This is to certify that Downs Henry & Brenda J Its owner
 has permission to Remove existing deck to add 1 story addition and new deck
 AT 9 Hope Ln 387 A038001

Comment Date	Comment			
06/29/200	left message w/owner . need to know size of frost wall, wall framing, sheathing, need temp glass framing details			
Name	tmm	Follow Up Date		Completed

Addendum Notes to Plans for Sunroom addition and Deck expansion
at 9 Hope Lane Portland

S ROOM MAIN FRAMING
 DETAIL : 1ST FLOOR

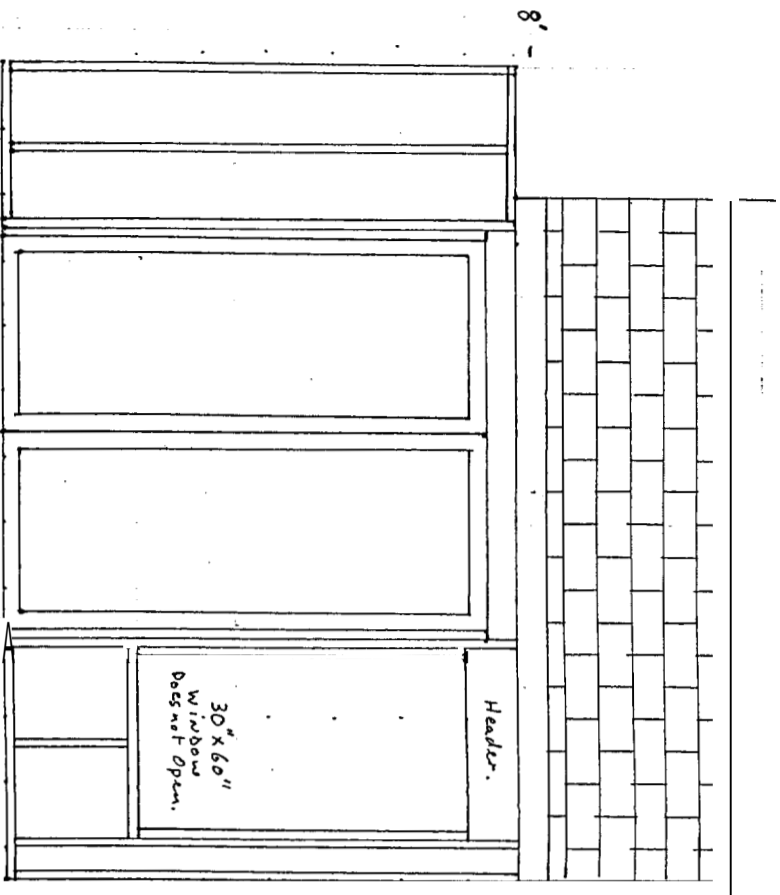
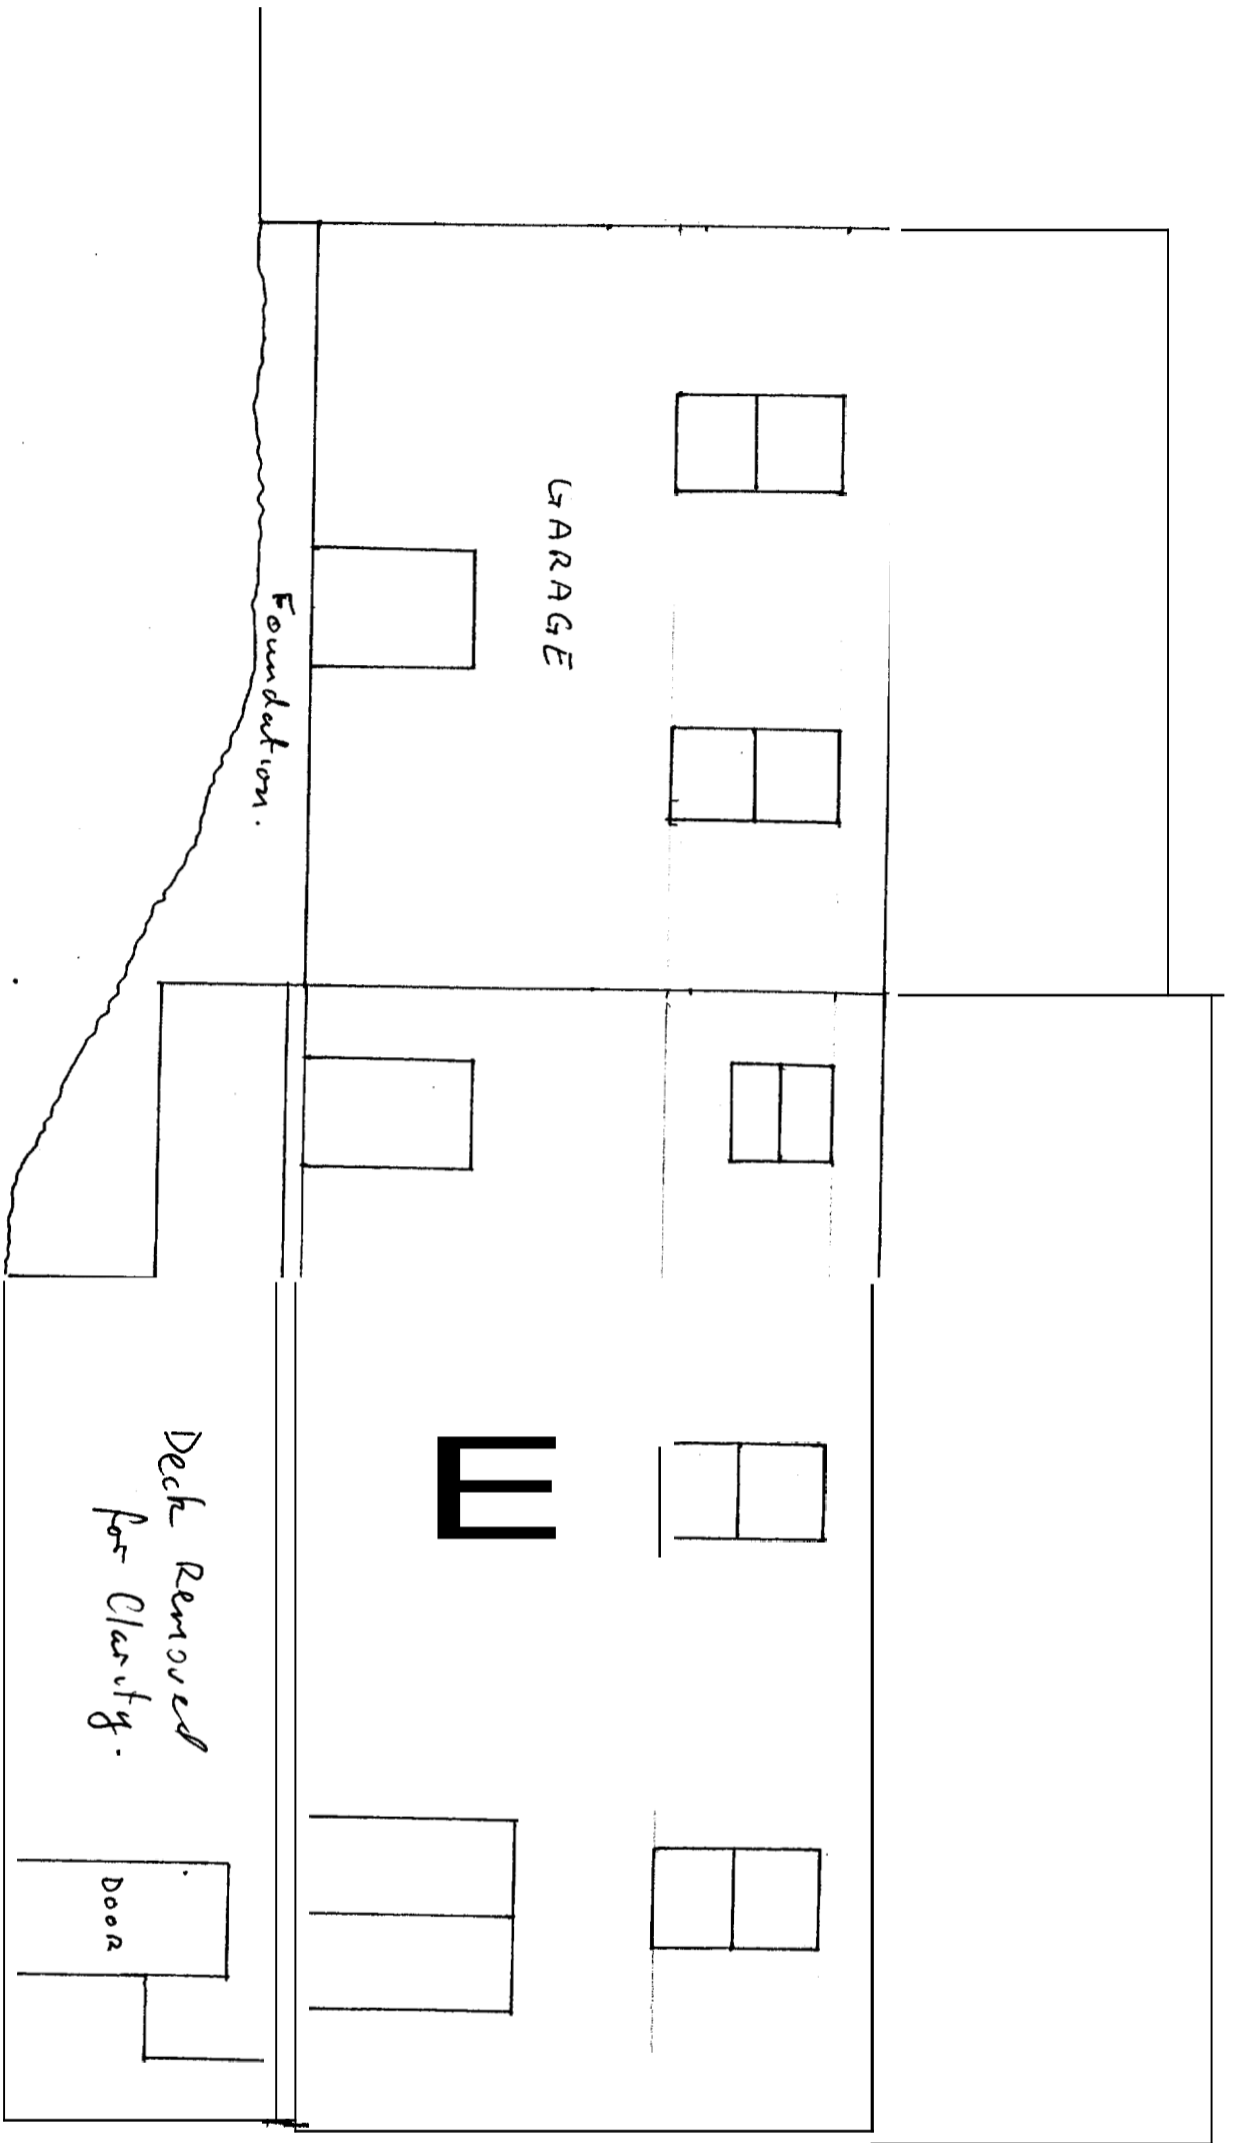
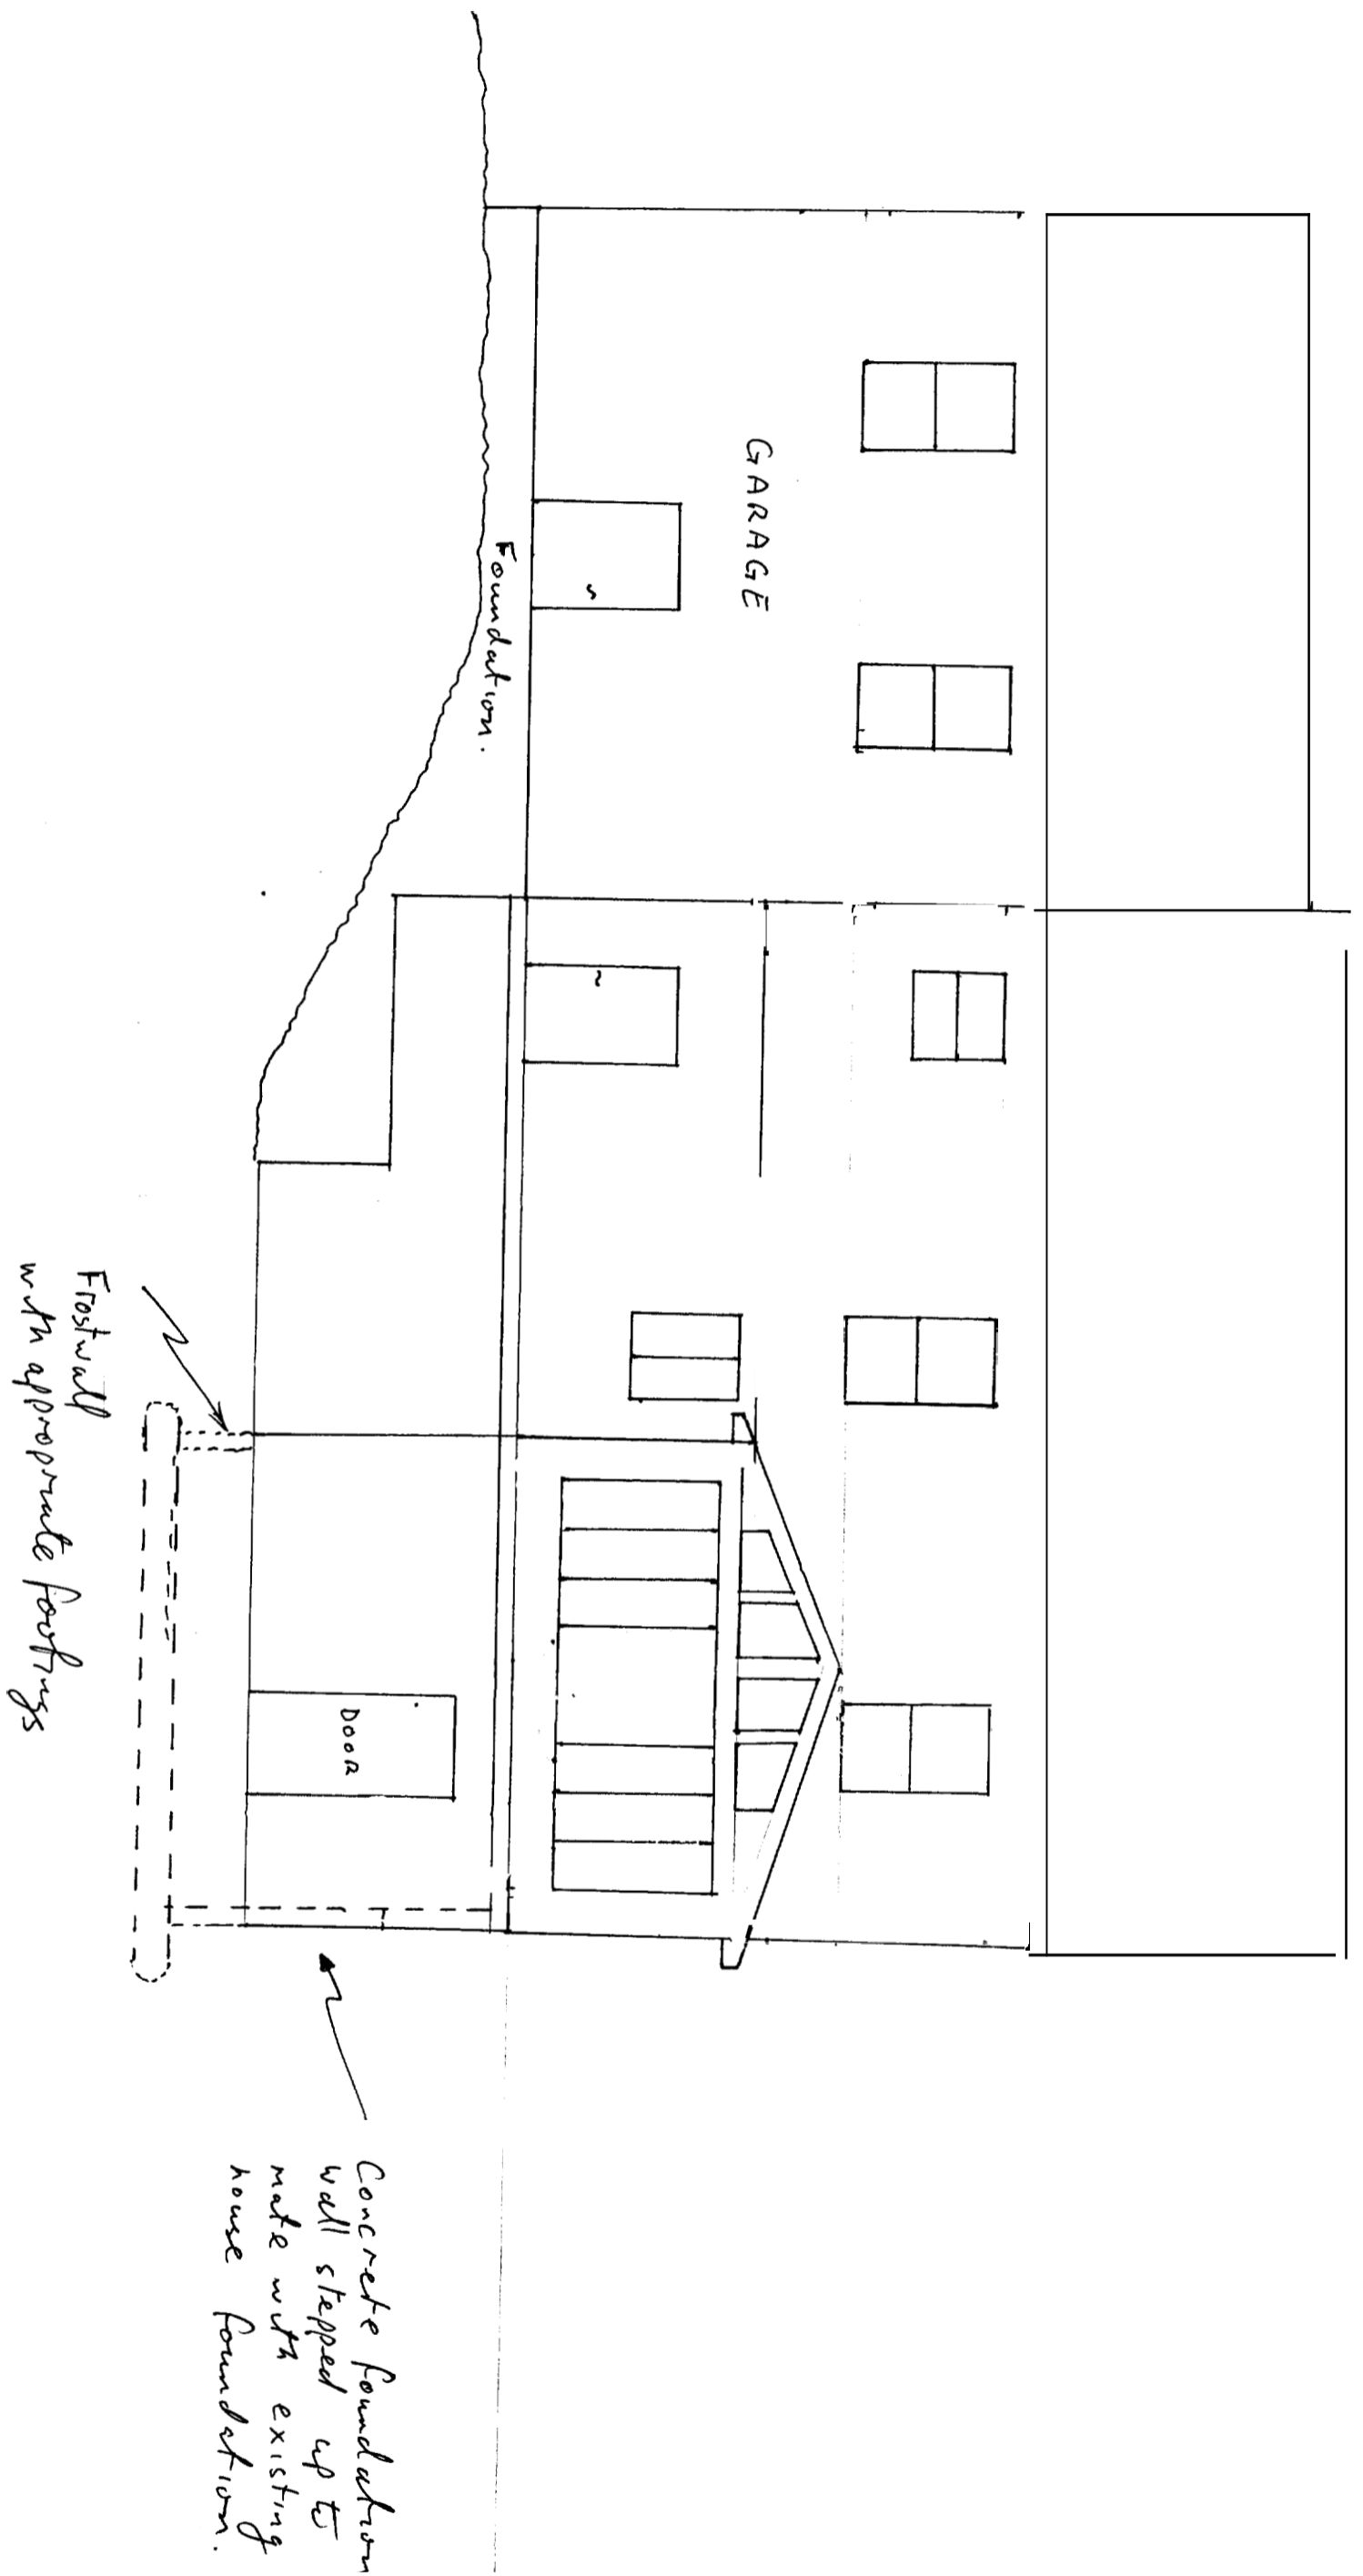
6/29/05-tmm: left message w/owner - need to know size of frost wall, wall framing, sheathing, need temp glass, deck framing details.

1. Framing and support details for the deck expansion are attached as part of this addendum.
2. Foundation specifications are attached as part of this addendum and will be added to design prints as required.
- ✓ 3. Any windows within 24" of a door opening AND/OR within 18" of the floor will be of tempered glass design.
- ✓ 4. Wall Sheathing to be 7/16 waferboard as approved by city codes.
- ✓ 5. Flooring to be 3/4 T & G underlayment.
- ✓ 6. Roofing sheathing to be 5/8 T & G plywood.
